Proposed Housing Development
in Farrankelly, Co. Wicklow

Stage 1 Road Safety Audit

Document Ref: P18-067-RP-001

PLAN VIEW 1
SCALE 1:250

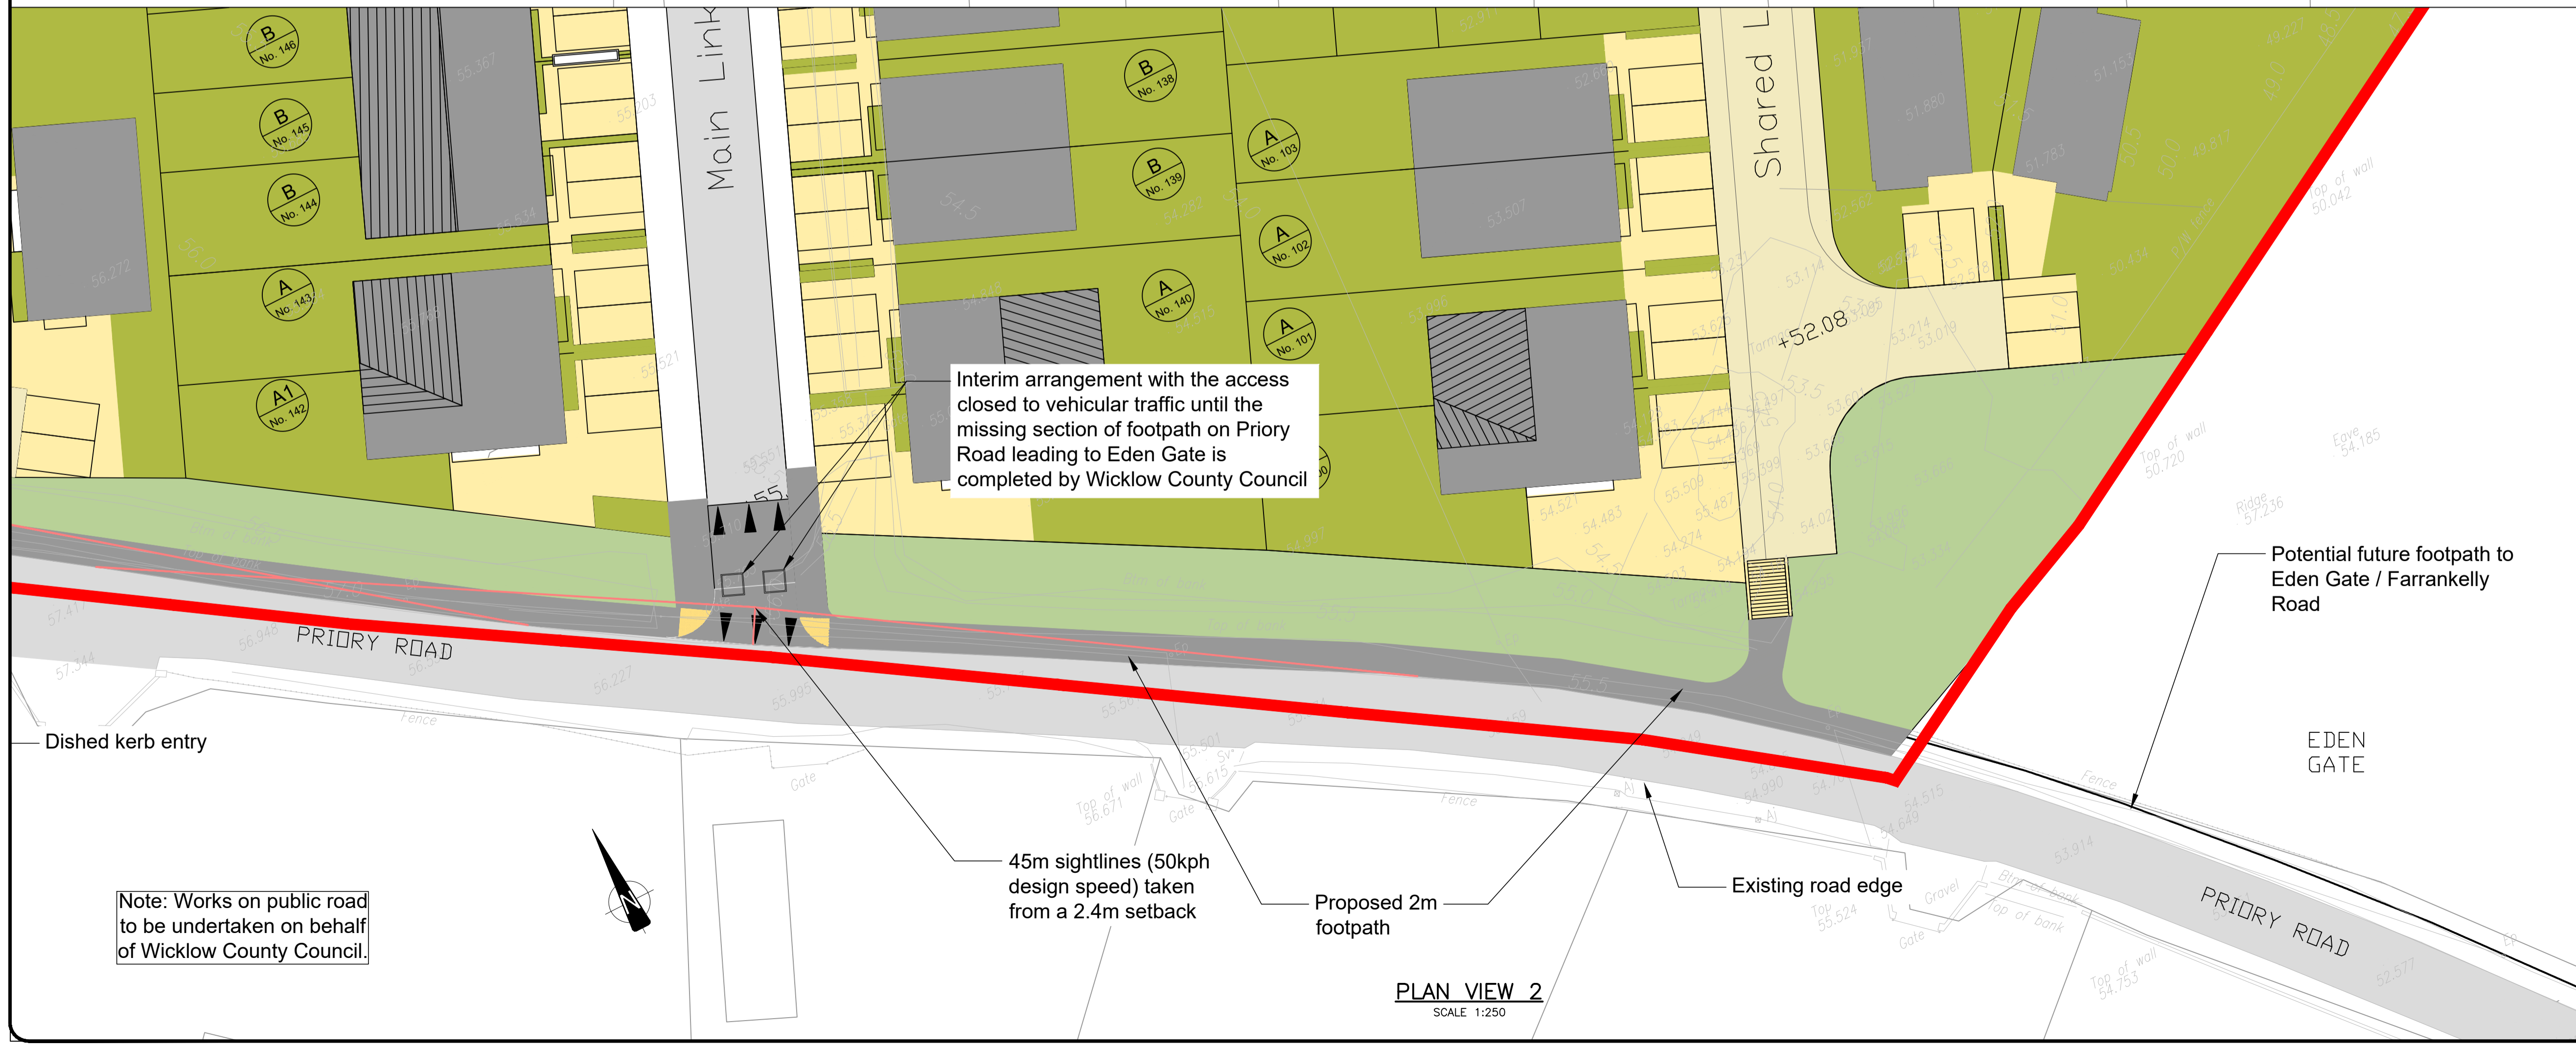
Summary: Several direct accesses onto Priory Road may increase the risk of side-on or rear-end-shunt collisions.

The proposed development includes three separate direct accesses onto Priory Road, as well as a new junction between Main Link Street 01 and Priory Road. The three accesses facilitate nine residential properties and 18No parking spaces. Having several direct accesses onto Priory Road, and within a relatively short distance, may lead to an increased risk of rear end shunt and side-on collisions. This issue is exacerbated by existing property accesses to the south of Priory Road, the horizontal alignment, and the rural character of Priory Road.

The proposed development should remove the three direct accesses onto Priory Road through the provision of a service lane that connects with internal residential streets.

3.1	No	No	The proposal to include direct accesses onto Priory Road has been developed in consultation with Wicklow County Council. The existing road already has a number of direct accesses and as the surrounding area is further developed the road will be upgraded to a suburban road with footpaths and lighting. The provision of the 3 direct accesses will be similarly spaced to the existing accesses on the opposite side of the road and this will help reinforce the suburban road objective. This is in keeping with DMURS and will help maintain appropriate traffic speeds as the road is upgraded.	Yes

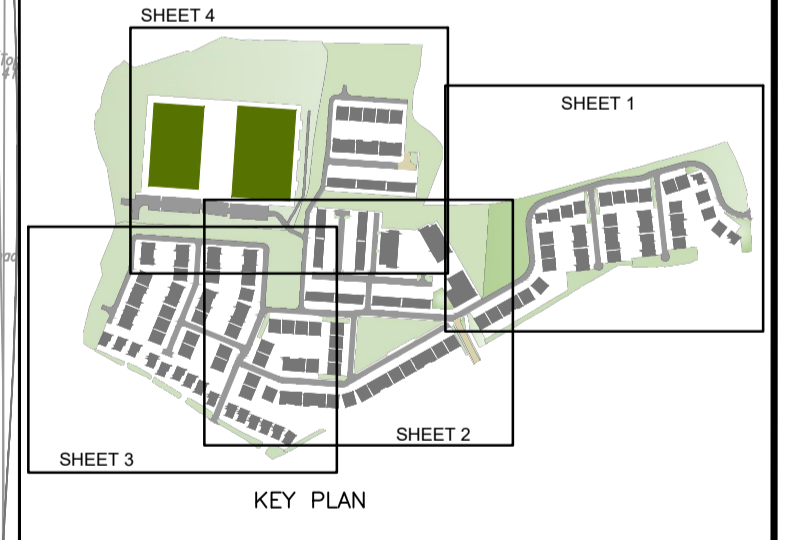
Summary: Unclear if there is sufficient drainage provision within the proposed development.

It is unclear at this early stage in the design process if sufficient drainage provision has been provided within the development. Should inadequate drainage measures be provided, this could lead to ponding on the footpath or carriageway resulting in slips and trips during wet or icy weather.

Ensure that the footpath and carriageway is adequately drained.

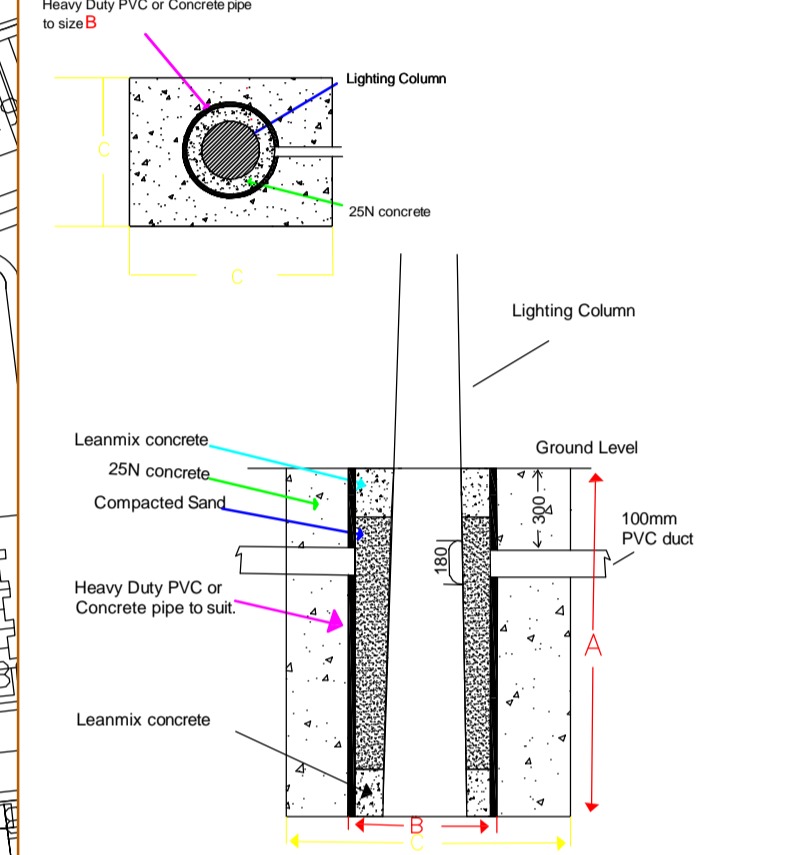
Summary: Unclear where public lighting columns will be located relative to the footpath.

At this early stage in the design process, information regarding proposed public lighting columns has not been provided to the Audit Team. It is assumed that public lighting columns will be provided throughout the proposed development. It is unclear, however, if these public lighting columns will be located within grass verges or within the footpath. Should public lighting columns be located within the footpath the effective width of the footpath will be reduced resulting in pedestrians having to enter the carriageway to avoid the obstruction leading to an increased risk of collisions with vehicles and cyclists.

Ensure public lighting columns are located at the back of the footpath or within the grass verge such that they do not constitute a hazard to pedestrians. Care should be taken to ensure that they are not located close to trees and other vegetation.
